From: Lindsay Darden
Sent: Friday, July 10, 2020 11:04 AM
To: aschuelke@thomasgc.com
Subject: Shoppes at Meridian Ranch - Site Inspection 7-10-20
Attachments: 1655_001.pdf; 1656_001.pdf

I visited the Shoppes at Meridian Ranch site and found the following:

DRAWING NO.
1
 SITE DEVELOPMENT PLAN

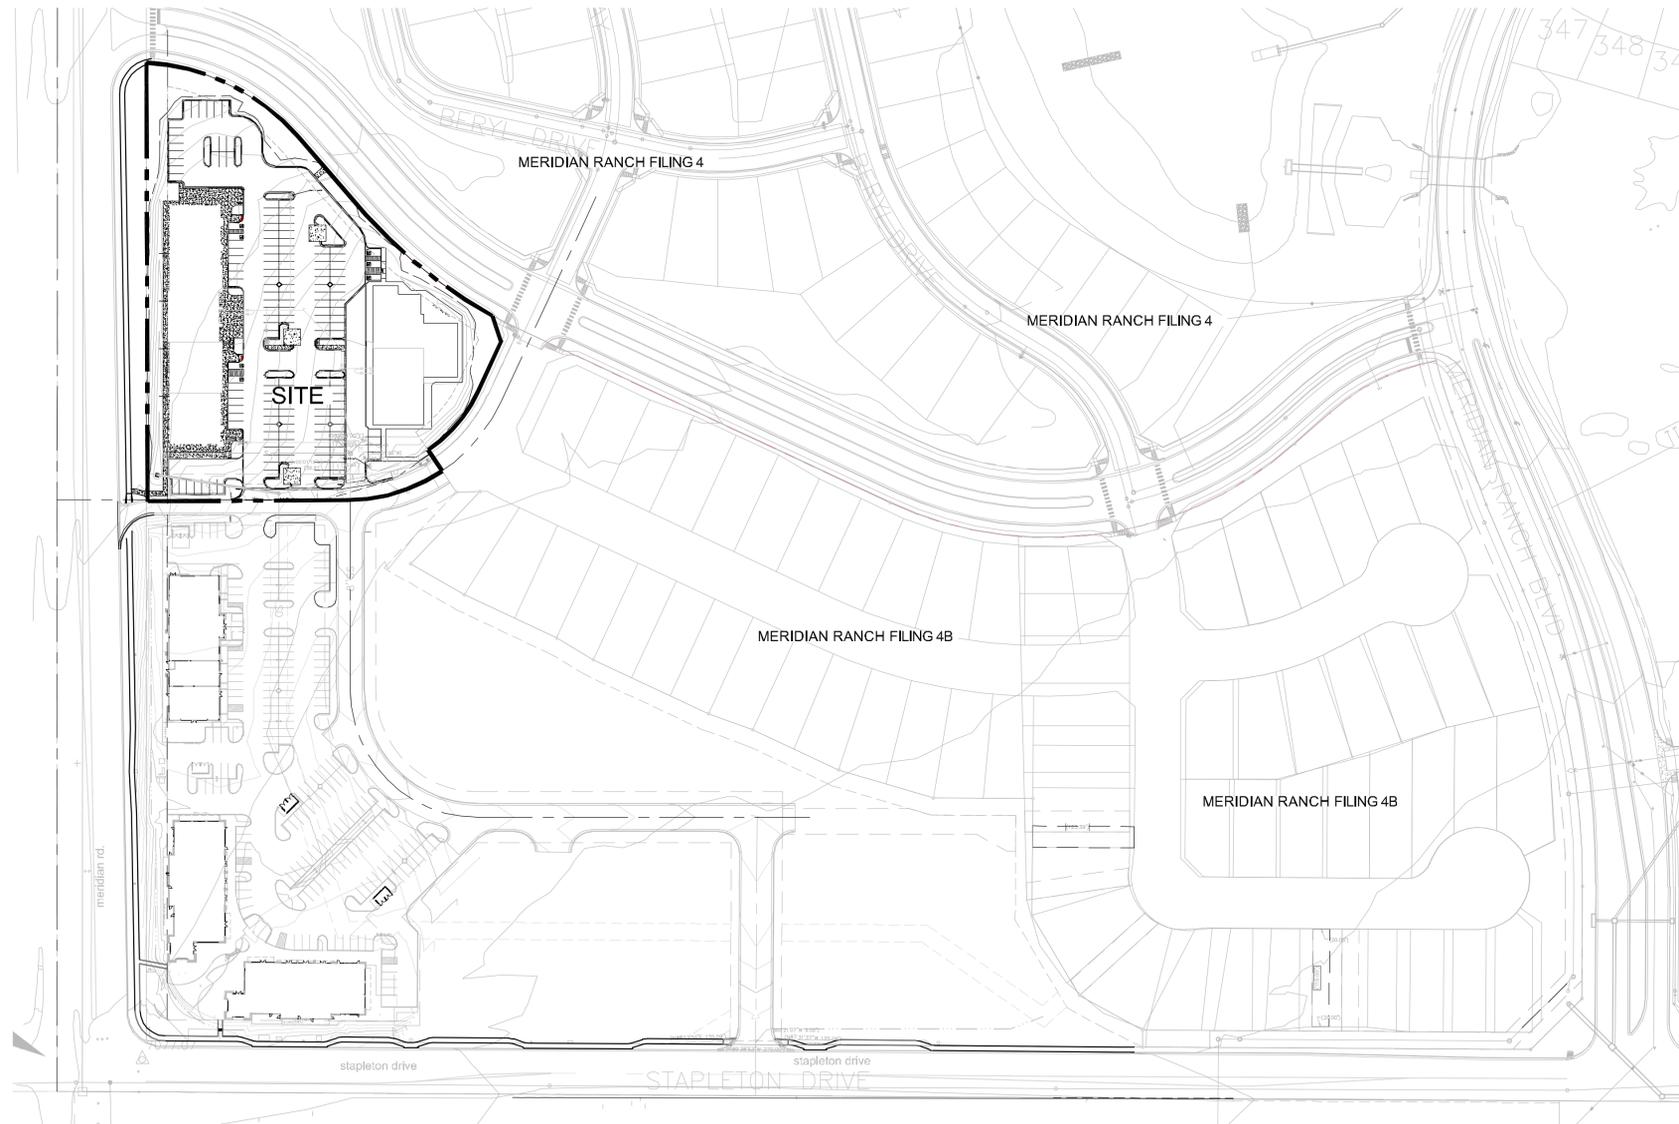
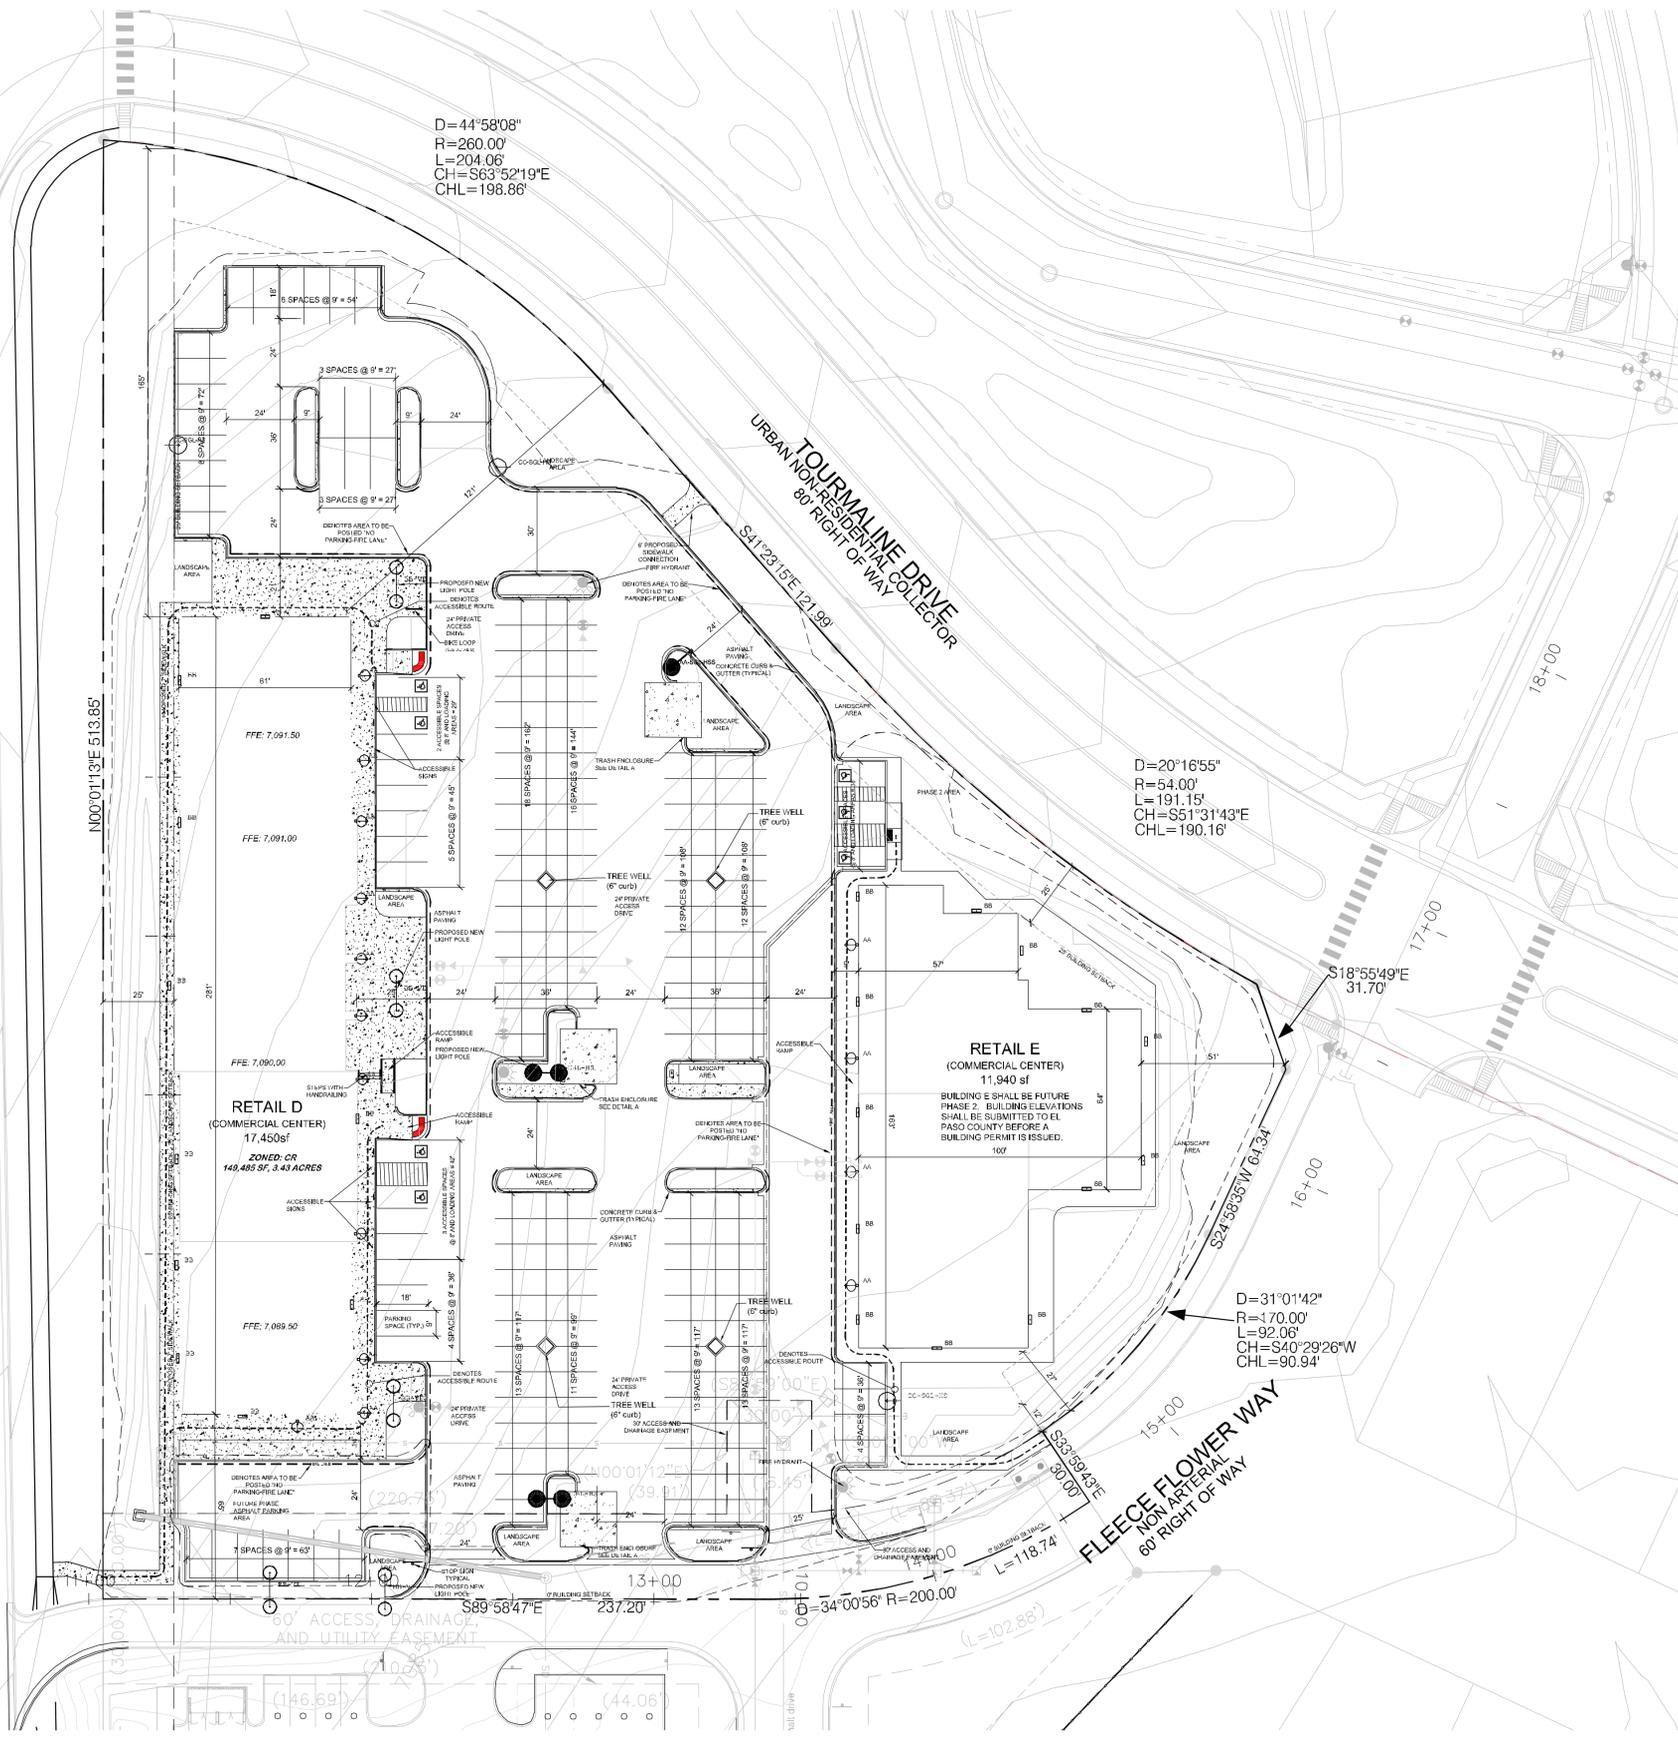
Site Plan – I marked areas where the parking spaces do not match what was graphically shown on the plan
Elevations – The elevations we have in our approved site development plan do not match what was constructed
Lighting Plan – New lights have been added, others are not shown where they were approved.

To resolve the site plan, elevations, and lighting issues, we will require submittal of a Commercial Site Plan (COM). If you give me the info on who should be the contact, I can set that up and send out a submittal request for the revised drawings.

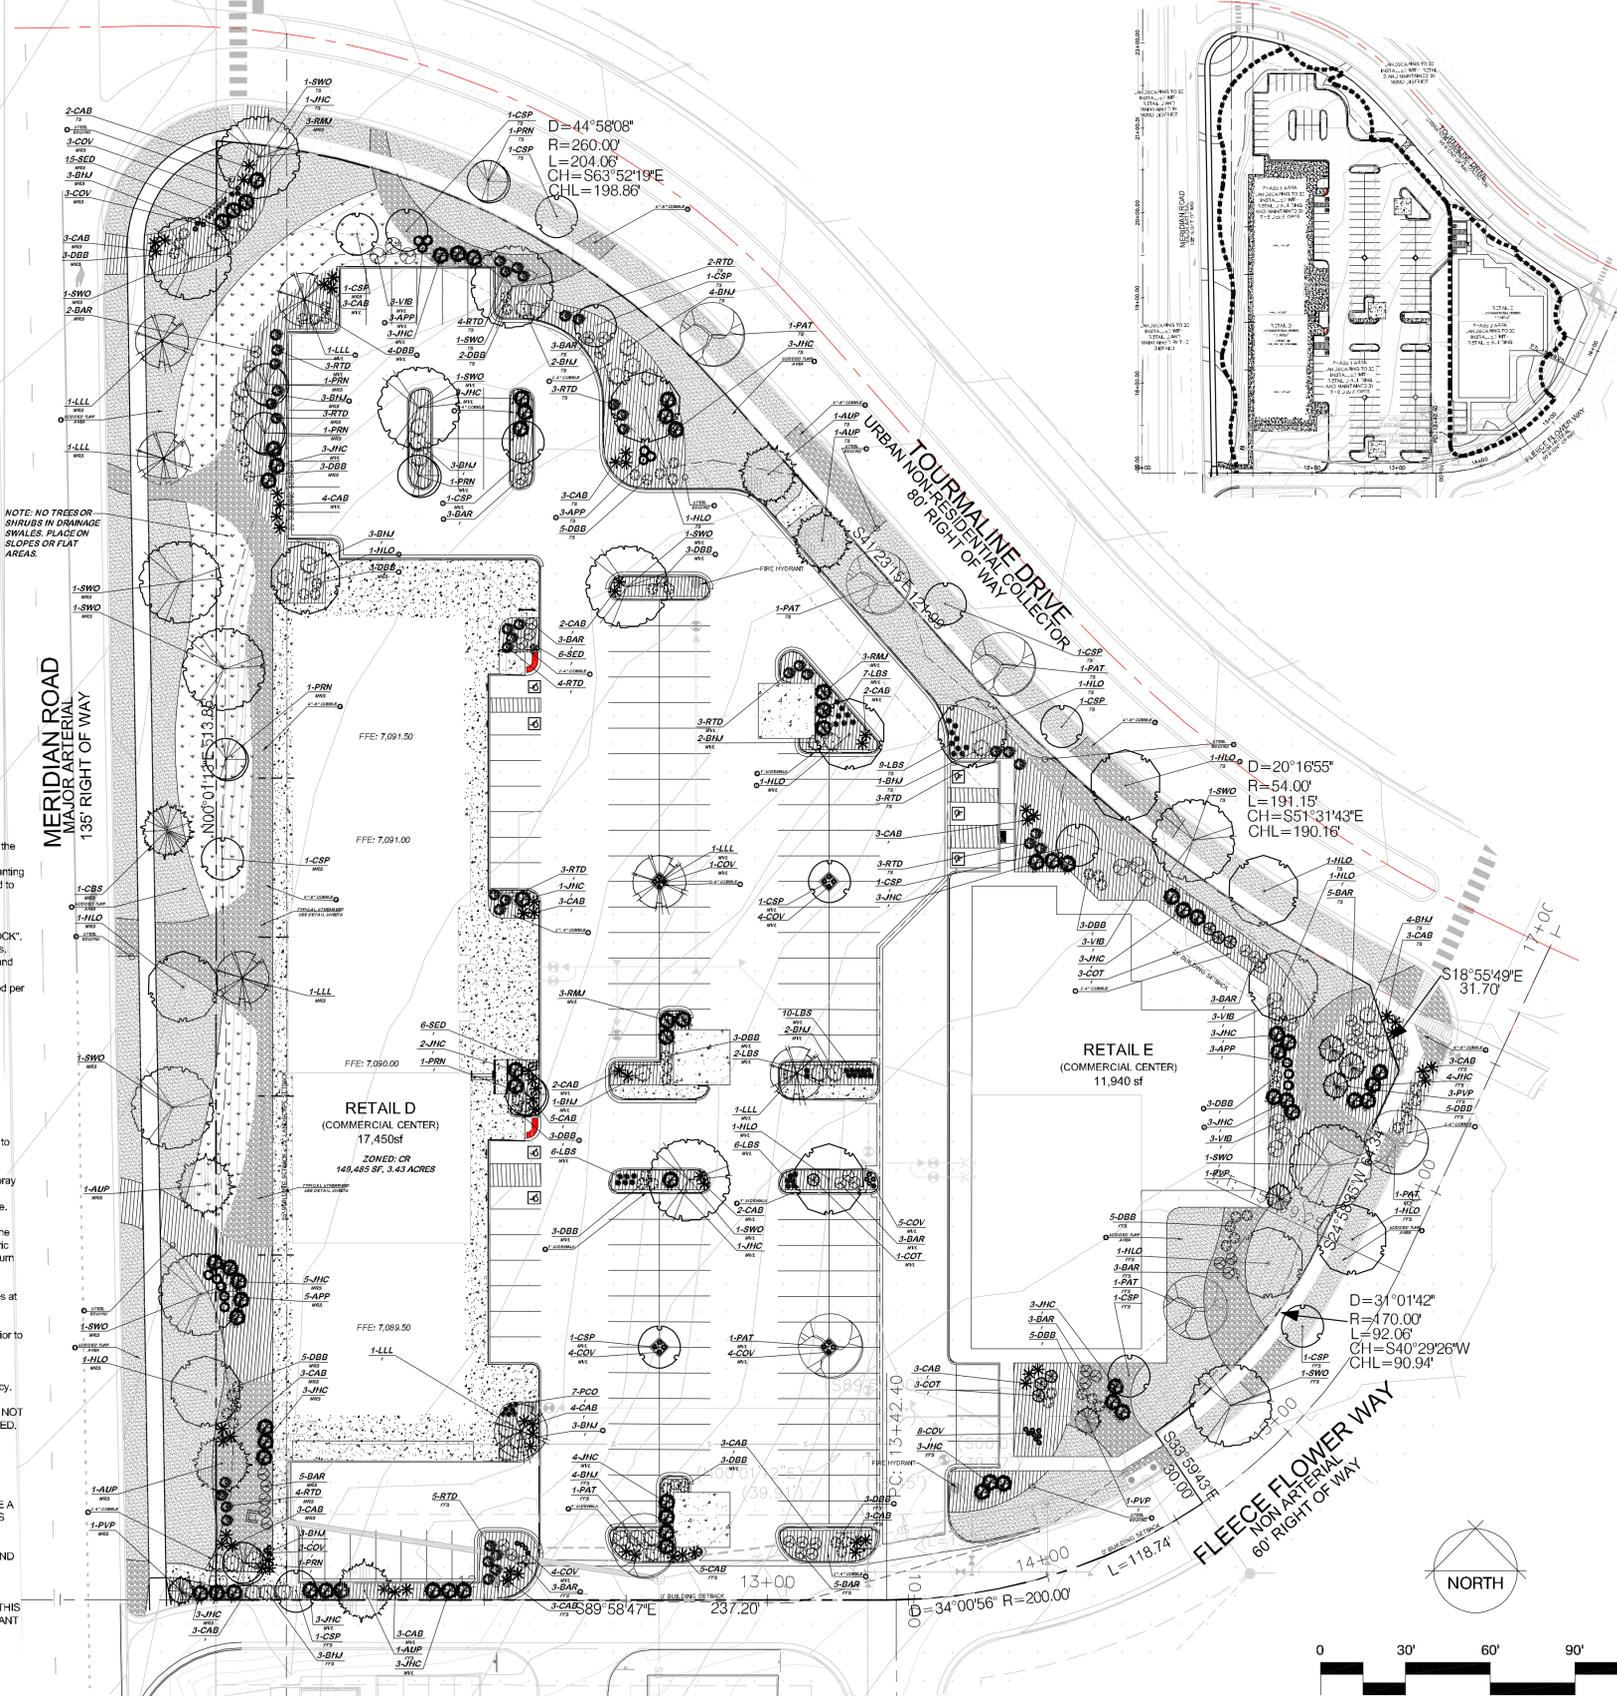
Landscaping – I highlighted the general areas of the plan where I noticed that landscape materials are either missing, dead, or stressed. You have a landscape agreement in place with collateral so we can allow extra time if you want to see if the stressed material leafs back out. Alternatively, if you prefer to get the project closed out, you can go ahead and replace the material.
